TO: Allison Kimball, Community Development Services
FROM: Christina Wollman, Planner II *CW*
DATE: February 13, 2009
SUBJECT: Firkins Short Plat SP-08-00055

Re: Firkins Short Plat, SP-08-00055

Thank you for the opportunity to comment on the short plat of approximately 15.13 acres into 2 lots, proposed by Charles Firkins [SP-08-00055]. We have reviewed the application and have the following comments.

**FIRKINS SHORT PLAT**

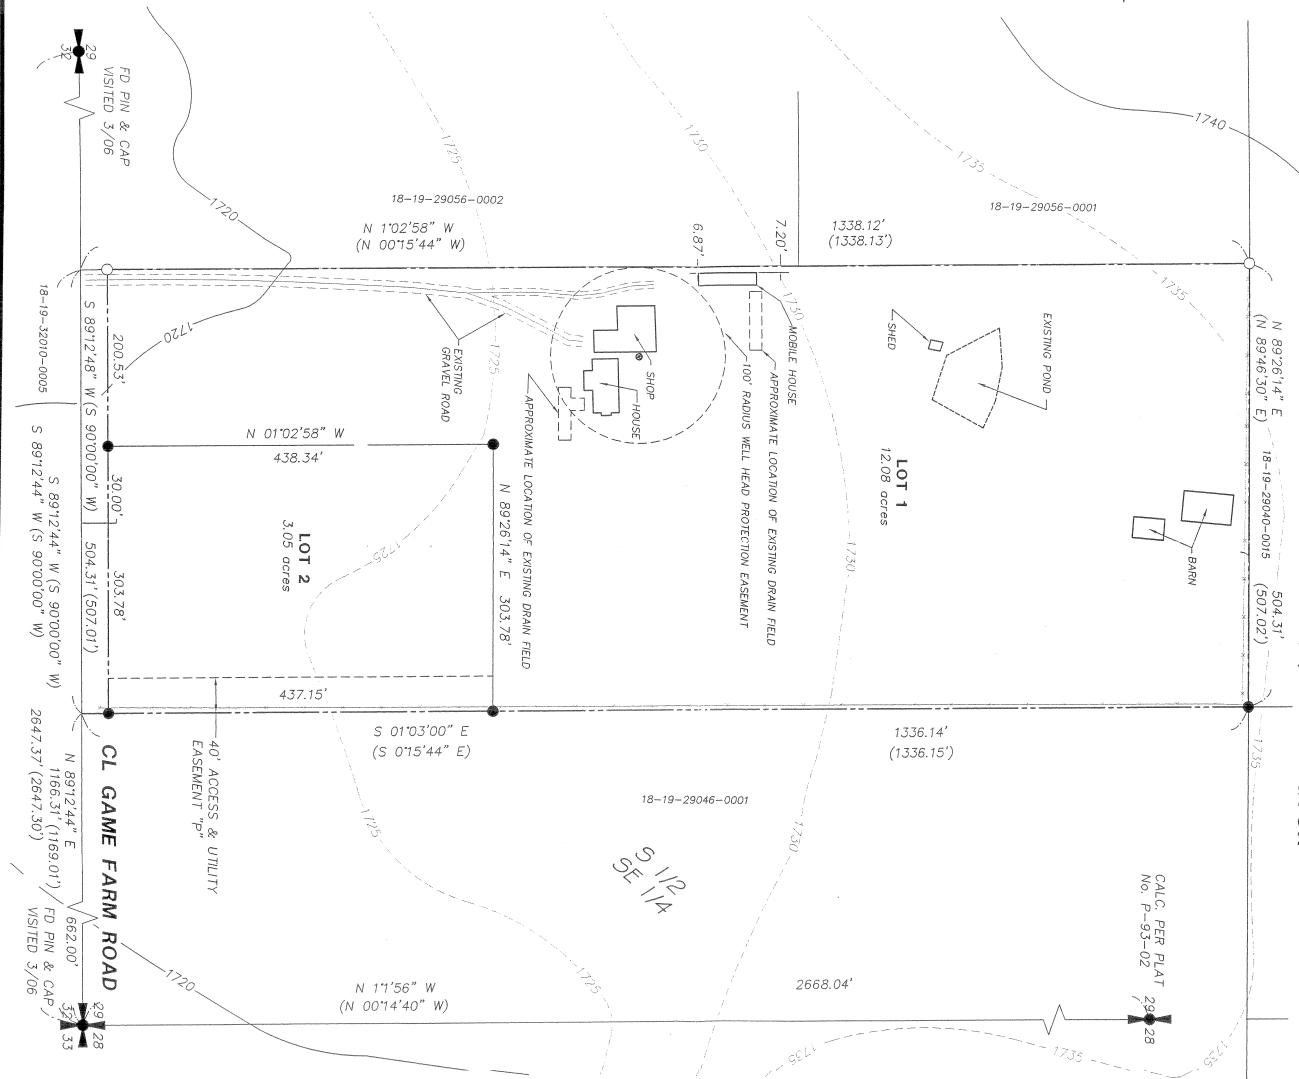
1. **Access:** Access to each lot shall be a single-use driveway. Lot 2 shall be accessed from Easement “P”.

Single-Use Driveway: A single-use access shall serve no more than one lot. See Kittitas County Road Standards, 9/6/05 edition.
 - a. The roadway shall be a minimum of 8’ wide with gravel surface.
 - b. Maintenance of driveway approaches shall be the responsibility of the owner whose property they serve. The County will not maintain accesses.
 - c. Any further subdivision or lots to be served by proposed access may result in further access requirements.
2. **Game Farm Road Right of Way:** The entire right of way of Game Farm Road shall be shown on the final plat.
3. **Private Road Maintenance Agreement:** The applicant shall meet all applicable conditions of any pre-established or required Private Road Maintenance Agreements.
4. **Lot Closure:** It is the responsibility of the Professional Licensed Surveyor (PLS) to ensure the lot closures are correct and accurate.

During this review I noticed that this packet failed to mention an open irrigation ditch which runs most of the length of the eastern edge of the applicant's property. I call this ditch the Burke ditch. I utilize this ditch to irrigate land which I lease (the Burke property) and land that I own to the south of the Burke property. I have concerns with the location of the easement road on the proposed plat. It appears that the Burke ditch as it lays now will conflict with the location of the proposed road. I am concerned about access for maintenance to said ditch. The use of this ditch has been exclusive to the Burke property and the property I own. The Firkins property has never irrigated from the Burke ditch. I have attached a copy of an aerial photo for your review.

I recommend several solutions to my above concerns. First, if the road location is granted as proposed I think the applicant should be required to pipe the Burke ditch the length of his property. In addition, this pipe should be exclusive to Burke and Schmidt properties, i.e. no new users. In any event, if the road is there or not I request the Plat and the Deeds of any future lots include verbiage to allow for future access and maintenance to the ditch or pipeline.
